Application No: M/97/21/PL
Site Address: 76-78 Flat Above Elmer Road Middleton-On-Sea PO22 6EX
Description of works: Retrospective application for first floor balcony. Proposed creation of 2 bedrooms within newly created roofspace, a resubmission of M/7/21/PL

Thank you for your internet representation made on 2nd November 2021 which has been recorded as an objection with the comments as follows:

Proposed West Elevation

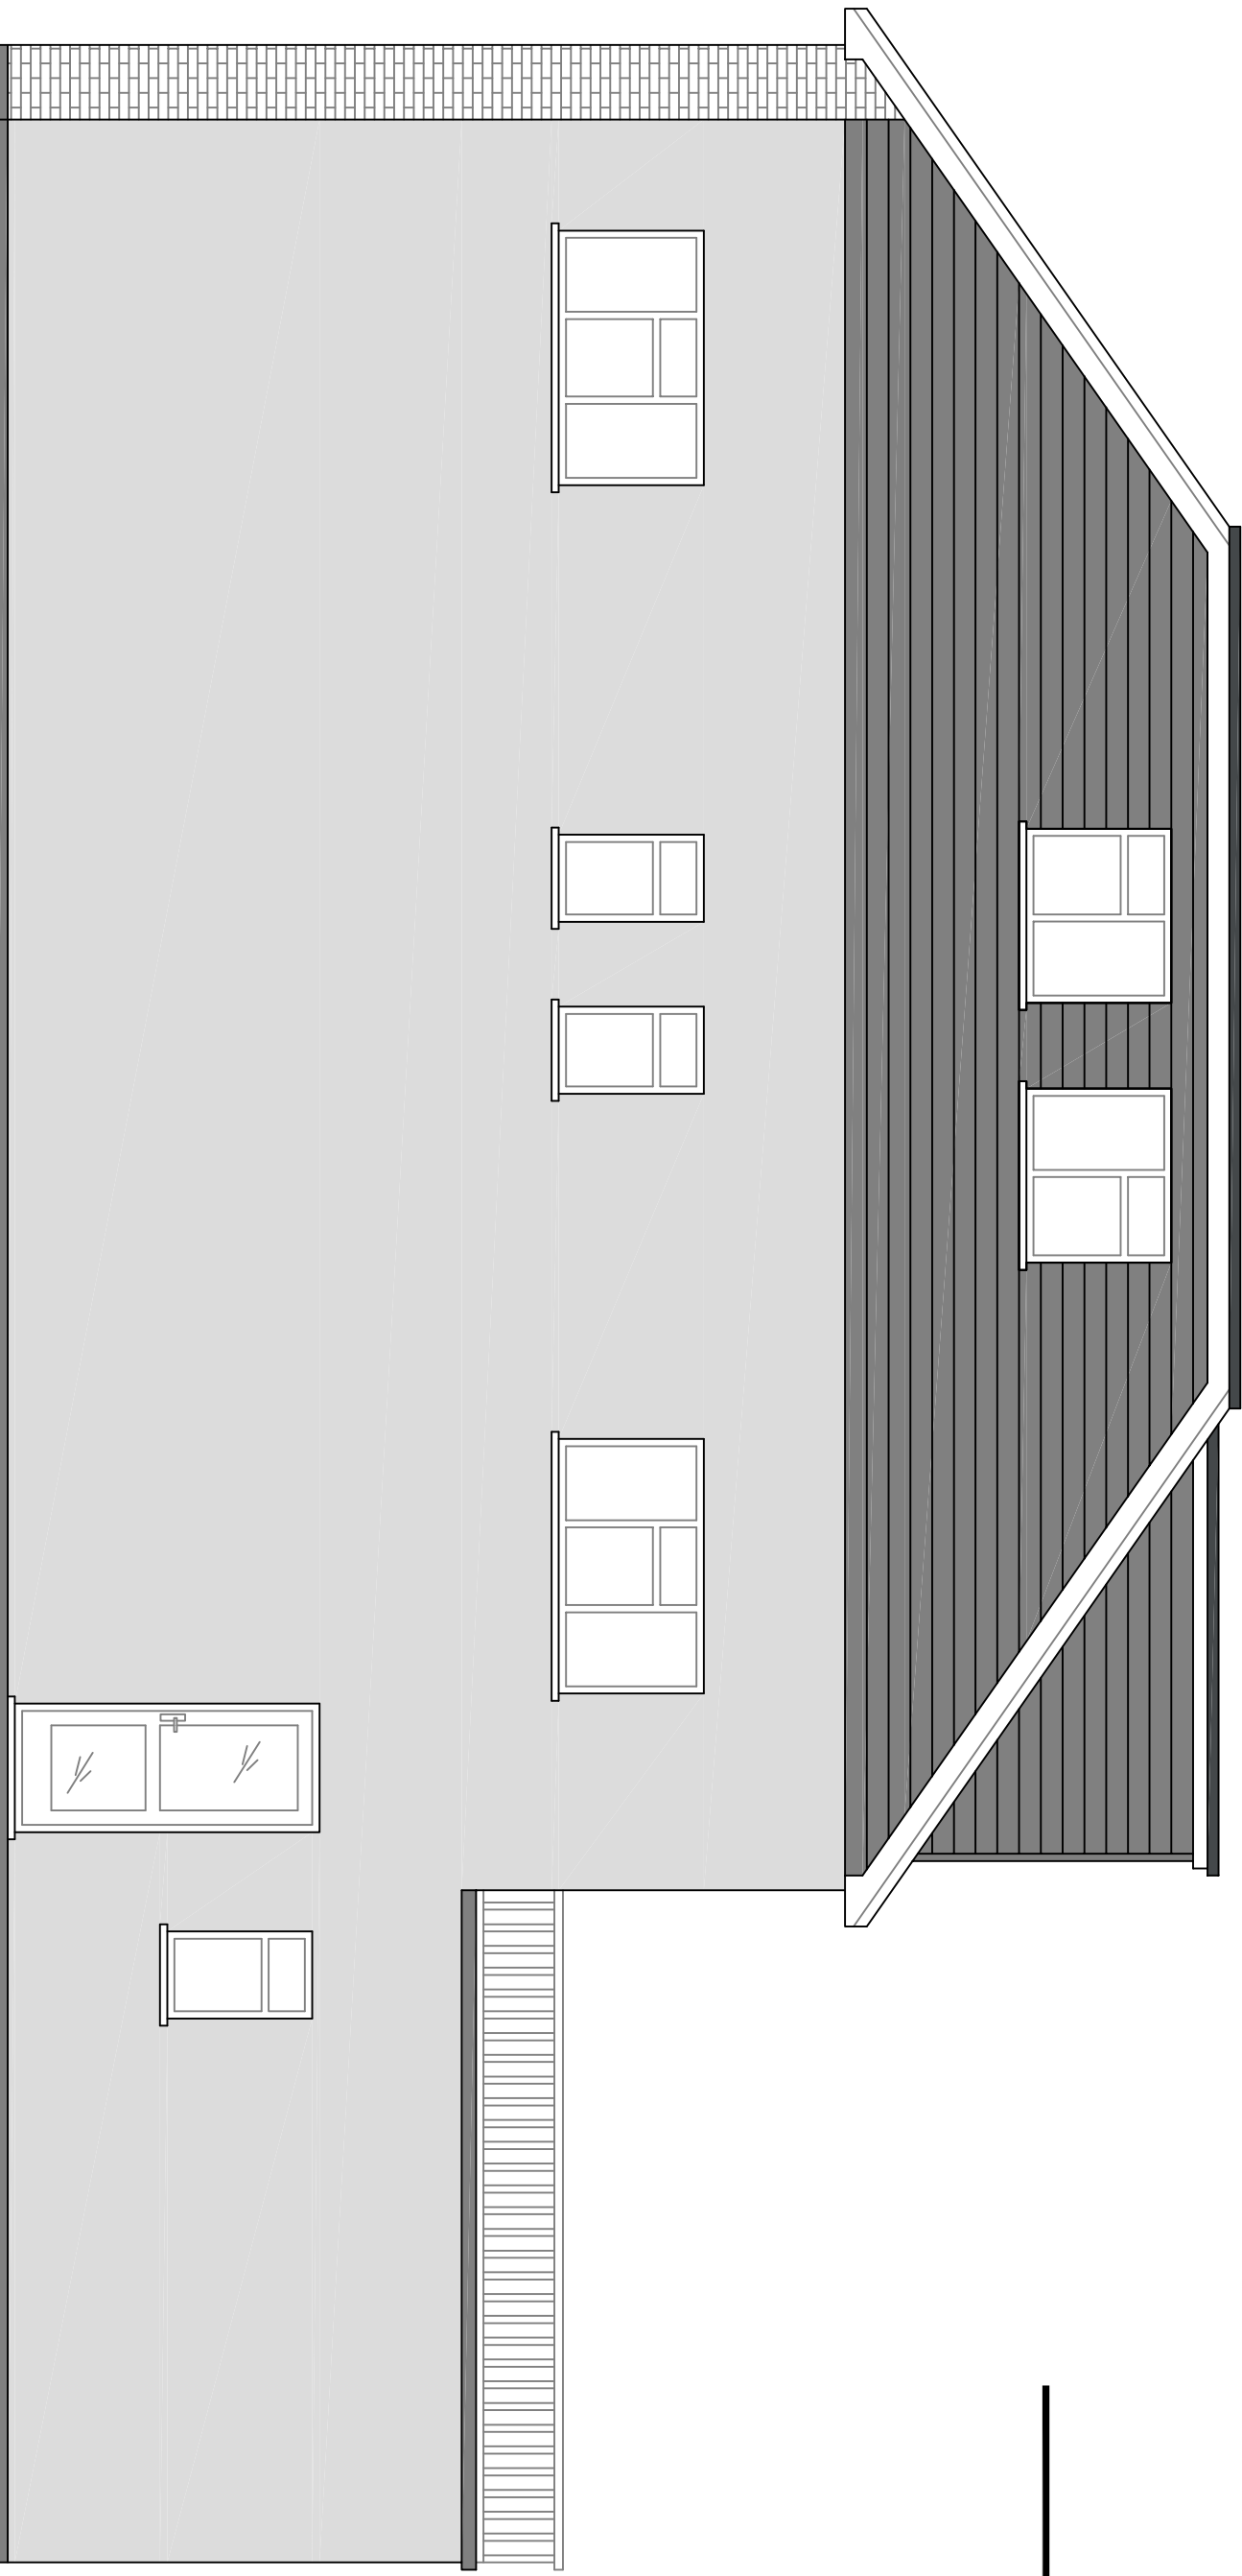
Privacy: The balcony that has already been illegally installed is ugly and intrusive. The photos clearly show how many people on Shaw Drive have lost the private use of their gardens.

The third story will further invade our privacy, is ugly and out of character. The architects and the planning department seem to be more worried about the street scene from the front of the property and not what the low lying properties to the rear of the applicant have to look at. The rear of the property is already unsightly and scruffy, these additions will make it completely overbearing for our tiny properties. The properties on Shaw Close were built in the 1920's and are therefore protected by under the law of privacy and light. The application is unneighborly and will be detrimental to the living conditions, amenities and privacy of the nearby
